BLACKTOWN HOSPITAL REDEVELOPMENT STAGE 2 – RESPONSE TO SUBMISSIONS

The Environmental Impact Statement (EIS) for the Blacktown Hospital Redevelopment Stage 2 (SSD 7058) was publicly exhibited between 5 November 2015 and 4 December 2015.

1 OVERALL PLAN LEVEL 5
10 1:1000

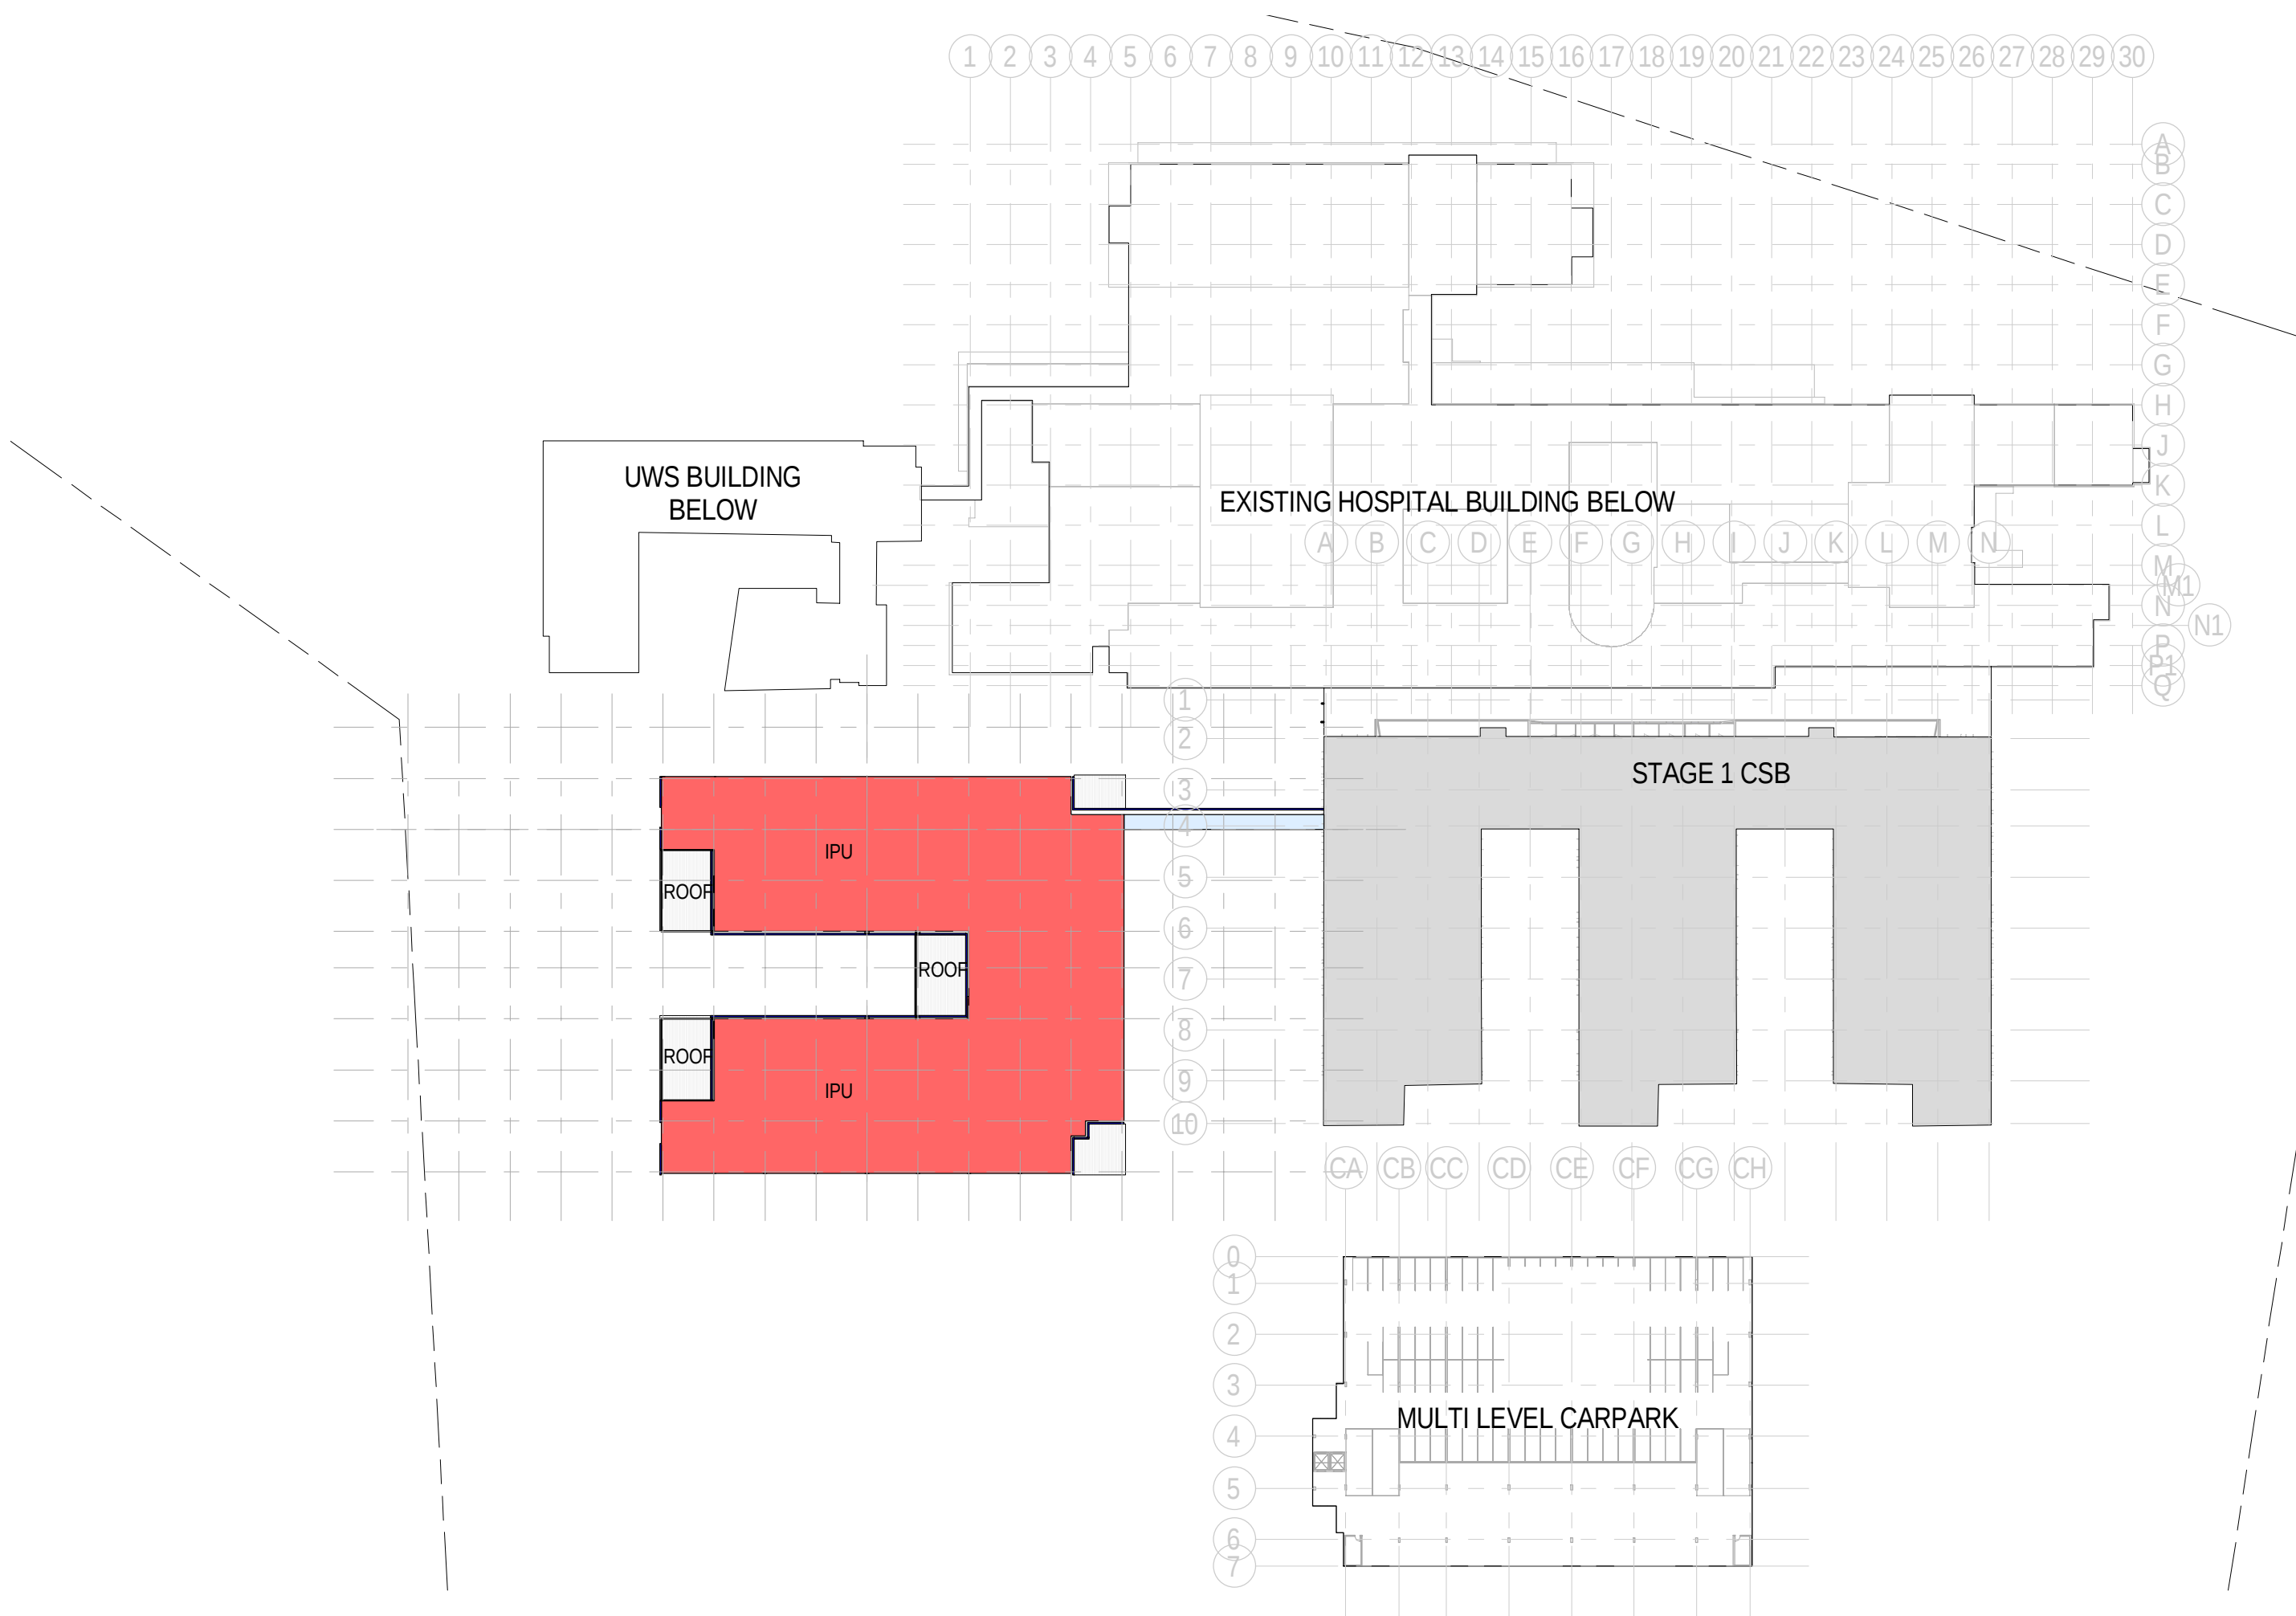
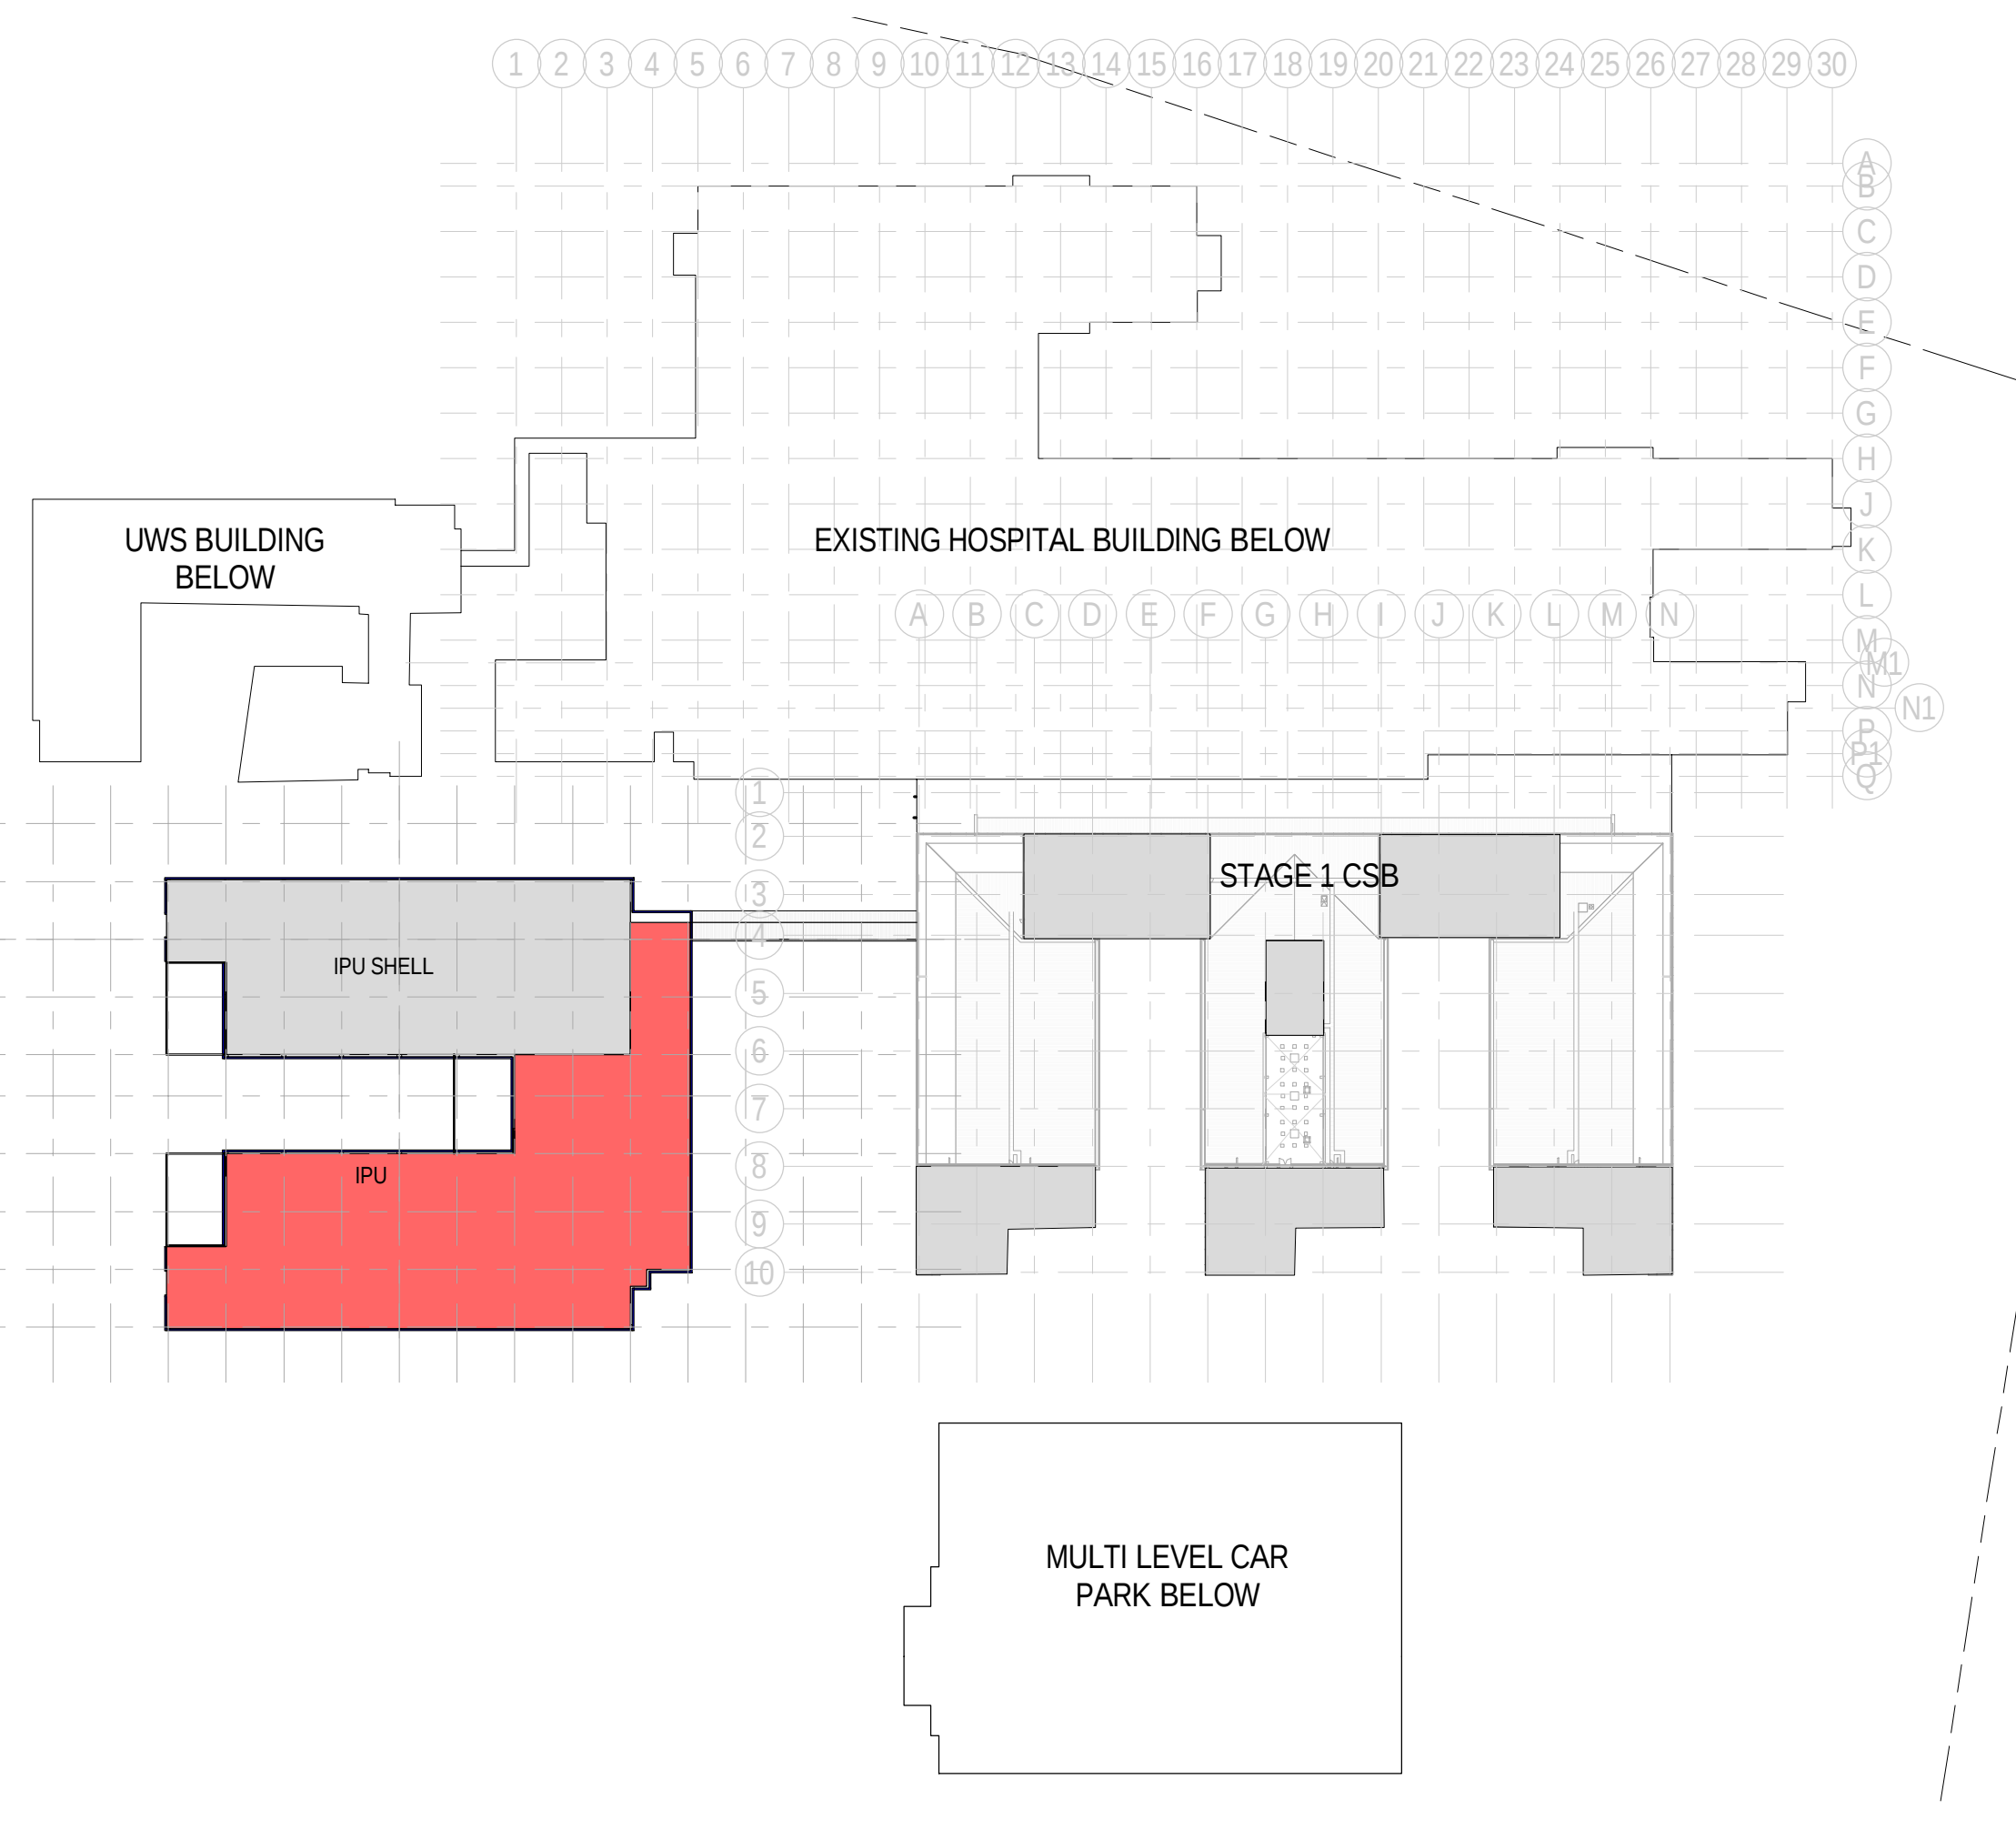
As a result of continued concept development and a better understanding of the functional needs of the facility a minor change as been made to the proposed envelope and massing. The tower elements have been reorientated to align east / west rather than north / south. The proposed changes will result in better functional relationships and ESD outcomes, and an improved outlook for patients.

Whilst the building footprint and envelope remain largely unchanged, the height of the building has been reduced. As shown on the updated plans attached, the height of the podium is the same, however the overall height of the building has been reduced to 9 storeys (including plant) from the originally proposed 10 storeys. As demonstrated in the revised shadow and massing diagrams, the changes to the envelope will not result in any additional shadow or view impacts.
